Ivanhoe Estate Redevelopment Concept – development application (SSD 8707)

CITY OF RYDE INITIAL SUBMISSION

IVANHOE ESTATE REDEVELOPMENT CONCEPT STATE SIGNIFICANT DEVELOPMENT (SSD 8707)

Drawing No: DA01.MP.100[3]

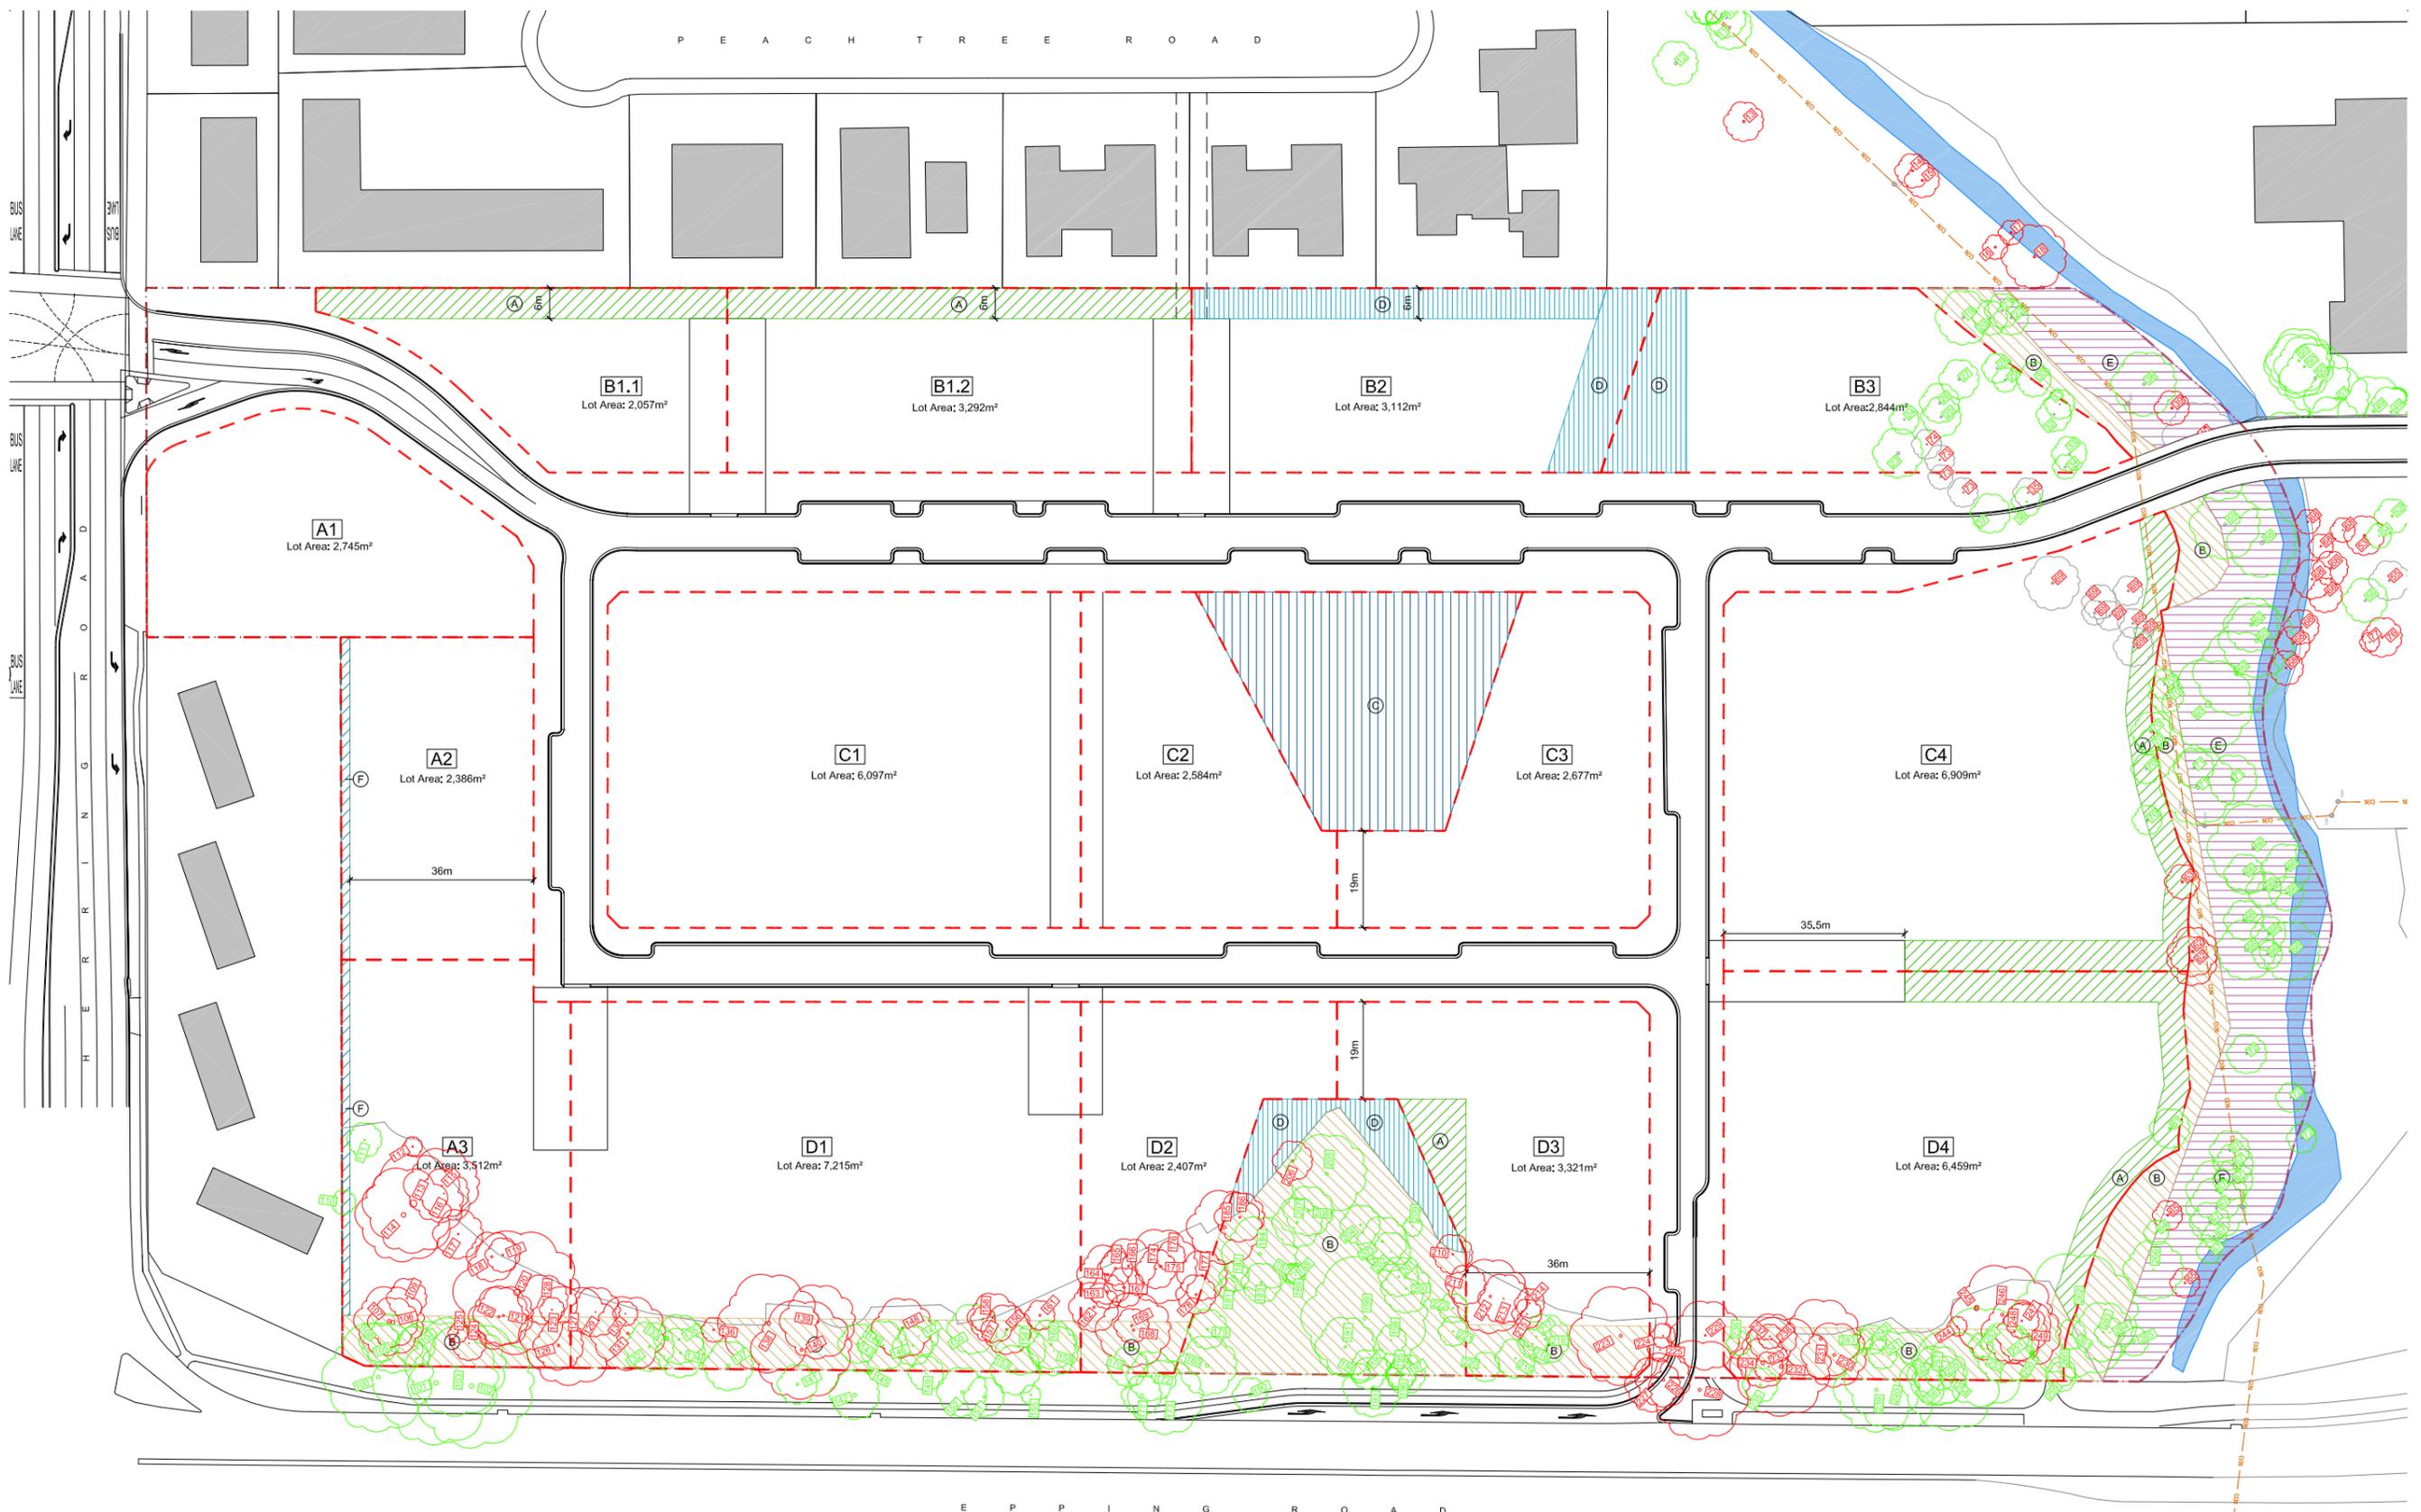
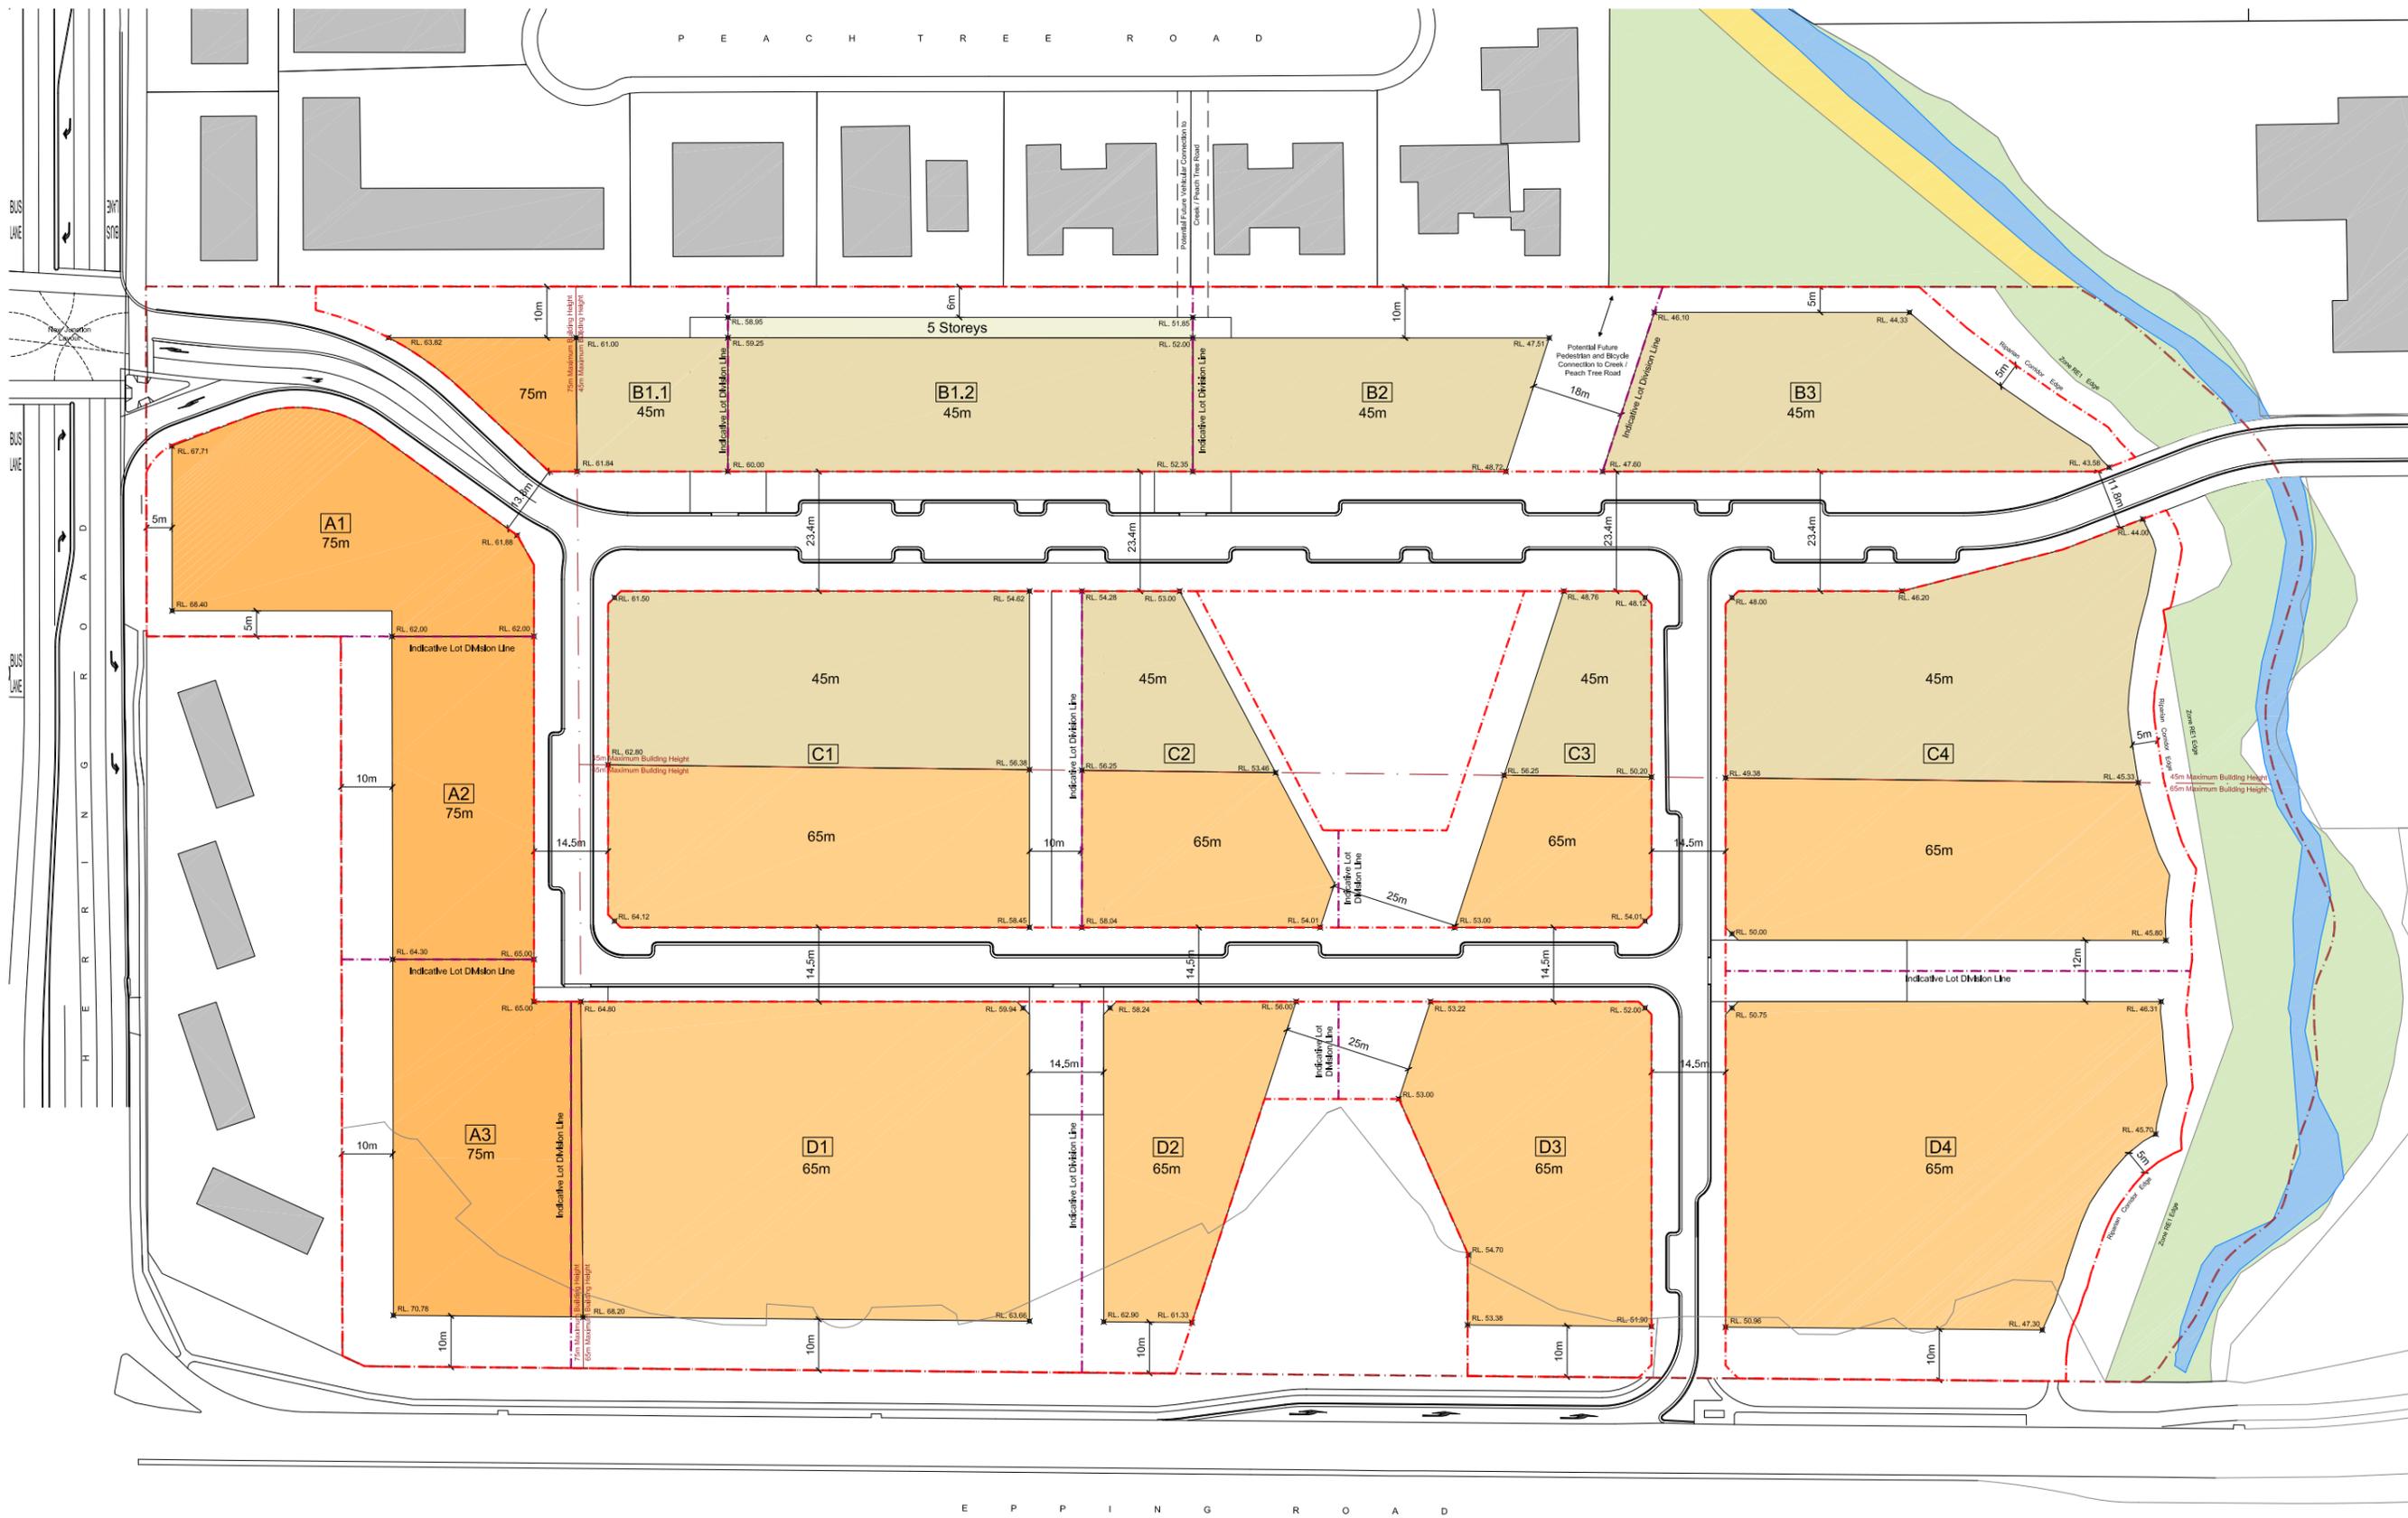
- b. **Building Envelopes in the Master Plan is confusing.** The Envelope Control Plan (DA01.MP.100[3] shows that the building envelopes for B1.1, B1.2 and B2 are connected to each other without the required building separation and could be misread should such a plan be stamped approved. Similarly buildings A1, A2, A3 and D1 are all shown connected to each other without regards for building separation and setbacks. The building envelopes should be setting an appropriate scale for future development in terms of bulk and height relative to the streetscape, block and lot sizes. As proposed, this plan may result in future development having a massing that is inappropriate for the desired urban form and character of the locality. This is the plan submitted for approval and must provide adequate clarity in relation to building footprint, boundary setbacks and the building separation distances.

- iii. Town square:** The proposed Envelope Control Plan (DA01.MP.100[3]) shows only a 10m wide town square reserve (space between C1 and C2) as well as a serious constraint on street reserves by narrowing points of the street reserve to only 11.8-13.8m for the main street. This is not acceptable. As previously discussed, the road reserves should be a consistent width in accordance with Part 4.5 of DCP 2014. This also results in unacceptable building separation distances between various buildings. The town square reserve should encompass its full width to deliver certainty as well as improve solar access. . The solar access to the town square is quite constrained due to building scale, the proximity of the full tower height and orientation. Podium setbacks should be provided to reduce the building scale and increase access to sunlight.

- iv. Lack of separation distance Building B1.1:** With reference to setbacks shown on Plan Number DA01.MP.100[3] a 10m setback proposed along the northern boundary with respect to building B1.1 at northern corner is not sufficient. The function of building (B1.1) is

not clearly identified on the plans. However, it seems that it will be apartment building. This building will be built to 14 storeys high and will require a separation of 24m between habitable rooms with respect to adjoining future developments along Peach Tree Road. A 12m clear separation setback is required from the boundary along the northern boundary. In order to comply with the ADG the proposal must provide increased setback of at least 12m along its northern boundary.

- ix. **Lack of separation between Buildings C3, C4, D3 & D4.** The Master Plan submitted for approval (DA01.MP.100[3] indicates that

the building will be separated by a combined distance of 14.5m between buildings which range from 14 storeys to 20 storeys. Council seeks that the plans must clearly show that building envelopes comply with the separations distance as required under the NSW Apartment Design Guide or a condition be imposed requiring all future detailed approval to fully comply with the building separation requirement in accordance with the ADG.

The Master Plan submitted for approval (DA01.MP.100[3]) indicates that the building will be separated by a combined distance of 14.5m between buildings which range from 14 storeys to 24 storeys. Council does not support built to line along the front boundary and therefore seeks the plans must clearly show that building envelopes comply with the separations distance as required under the NSW Apartment Design Guide or a condition be imposed requiring all future detailed approval to fully comply with the building separation requirement in accordance with the ADG.
